CUMNOR PARISH COUNCIL

21st July 2025

BOTLEY WEST SOLAR FARM (BWSF) REF: EN010147

Cumnor Parish Council's Comments for Deadline 3 on responses to Examining Authority's 1st written questions (ExQ1)

Swinford Bridge

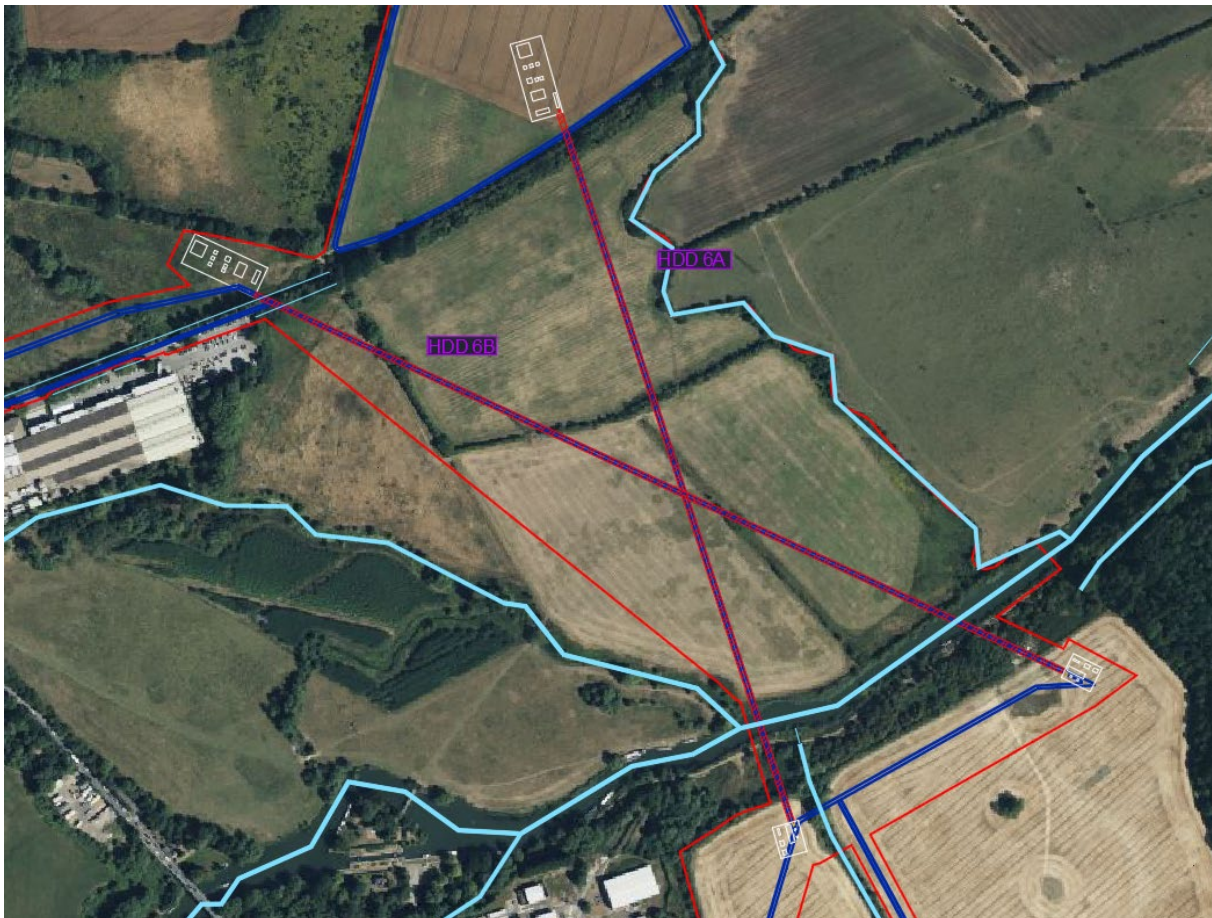
By focusing on '*a peak of up to four minibus movements per day crossing the B4044 Swinford Bridge*' given that '*construction HGVs will not travel across the B4044 Swinford Toll Bridge for any access purpose*' the applicant ignores the construction traffic that will approach the bridge from both the north and the south to construct the cable route river crossing.

Also, given current experience, and potential cumulative impacts of construction traffic for the proposed Red House Farm power station. the proposed Thames Water Farmoor power station, and the National Grid substation (see CPC submission re ExA Q 1.1.5 on page 1 of **EN010147-001136-Cumnor Parish Council - Responses to Examining Authority's First Written Questions (ExQ1).pdf**, CPC has a very low to zero level of confidence in the assertion that HGVs will not cross Swinford Bridge.
